City of Albuquerque

April 20, 1999

**RE: GRADING & DRAINAGE PLAN FOR RICHLAND HILLS PARK (C-12/D3B2)
RECEIVED MAR 24, 1999 FOR DRC WORK ORDER
ENGINEER'S STAMP DATED ?-?-99**

Design Review Committee	City Engineer Approval	Last Design Update	Mo. / Day / Yr.	Mo. / Day / Yr.			
City Project No.	566371	Zone Map No.	C-12-Z	Sheet	6	Of	15

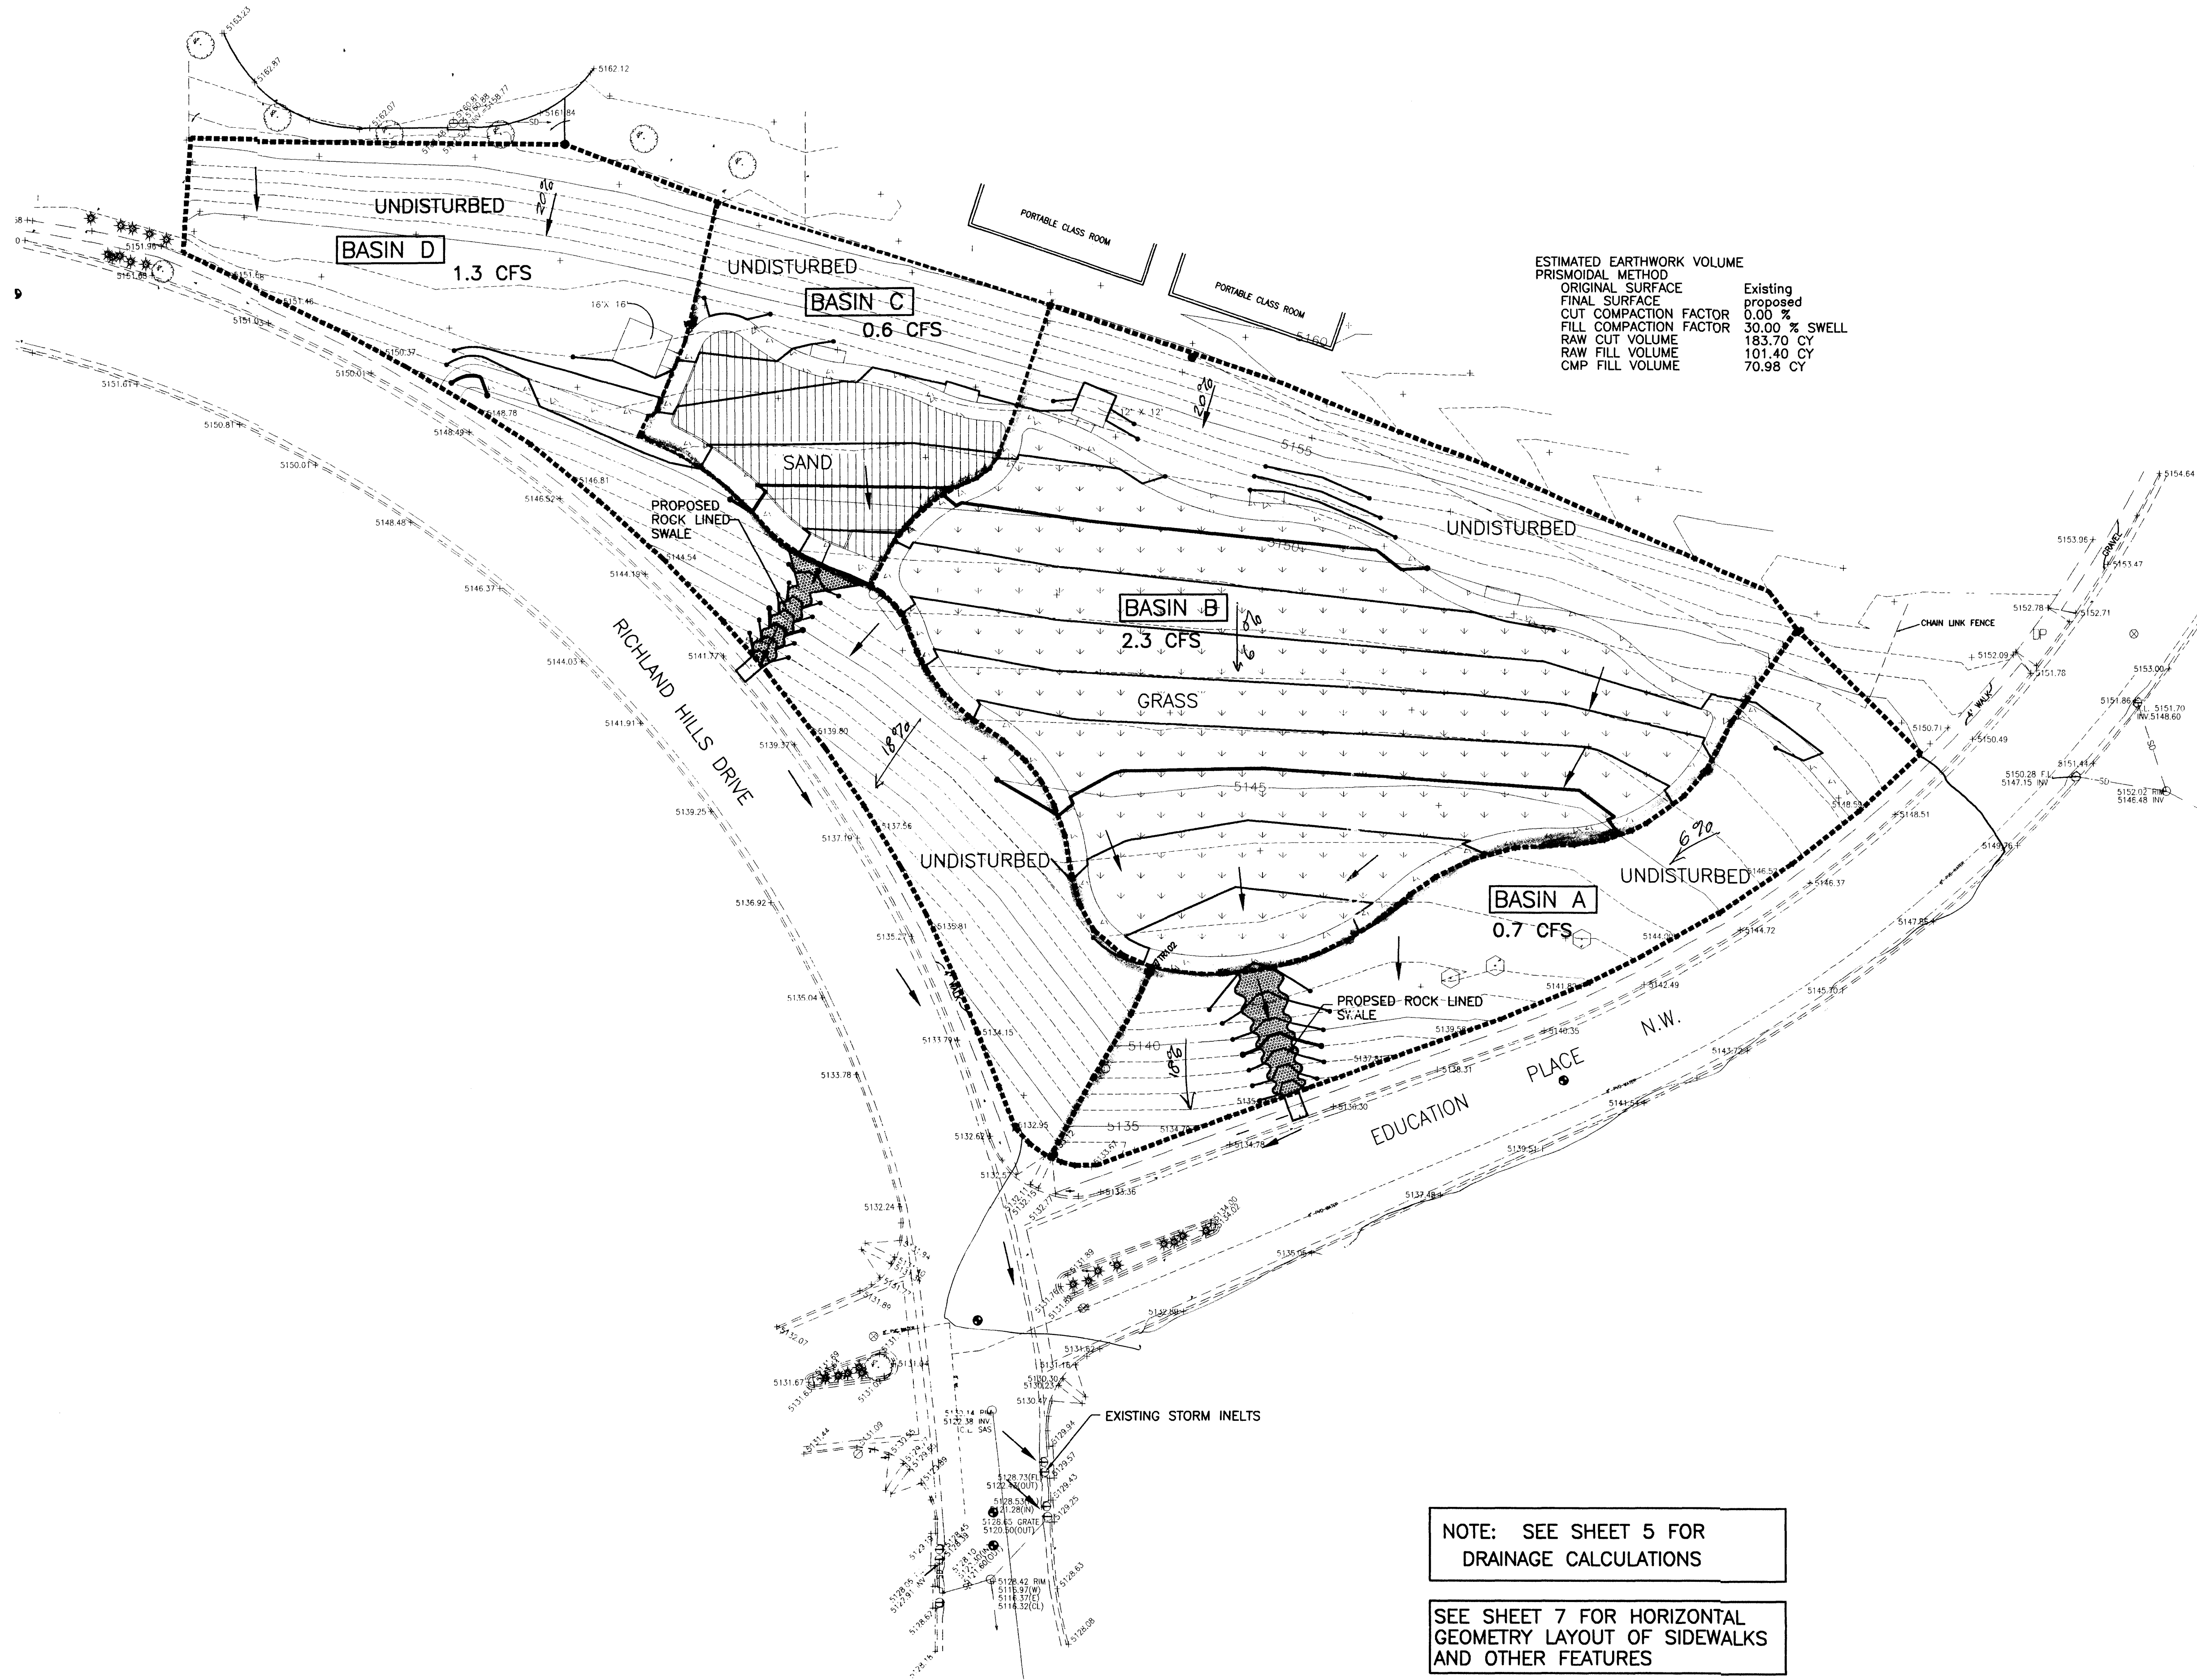
How do you plan to transition the 36" wide rock rundown into the 12' wide sidewalk culvert? Do the side slopes of the rundown need rock armoring? What is the weir capacity of the culvert?

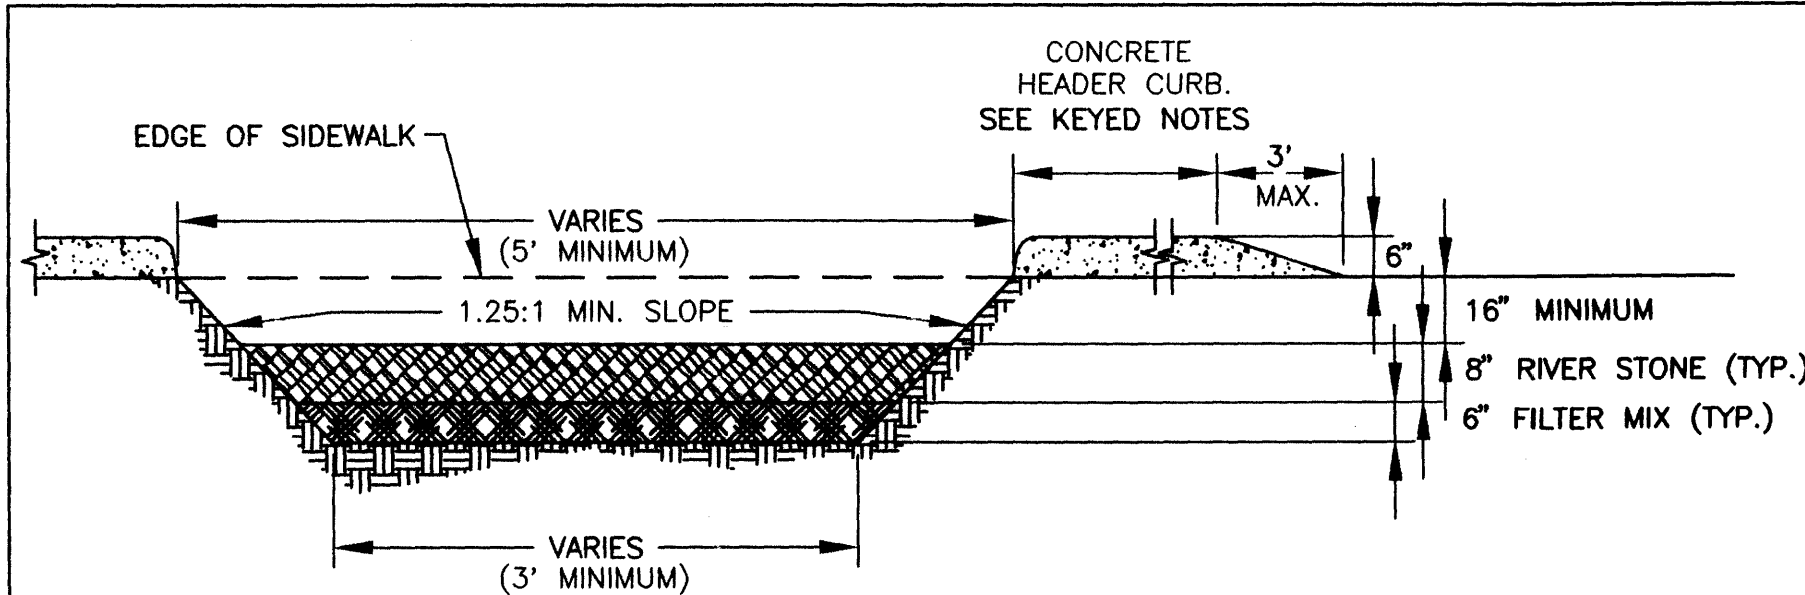
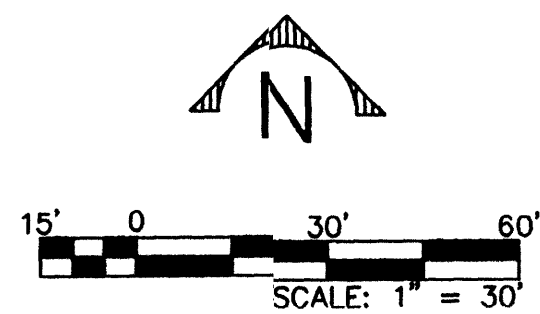
There are a few typos on Sheet 5: The discharge from Basin C is 0.6 instead of 0.9 cfs. The discharge from Basin D is 1.3 instead of 0.9 cfs. Based on the contours the slopes appear to be 20% or less. If the undisturbed areas sloped steeper than 20%, then they would be Land Treatment C instead of B. Why is the Park 0.6 acres smaller than Basin 112?
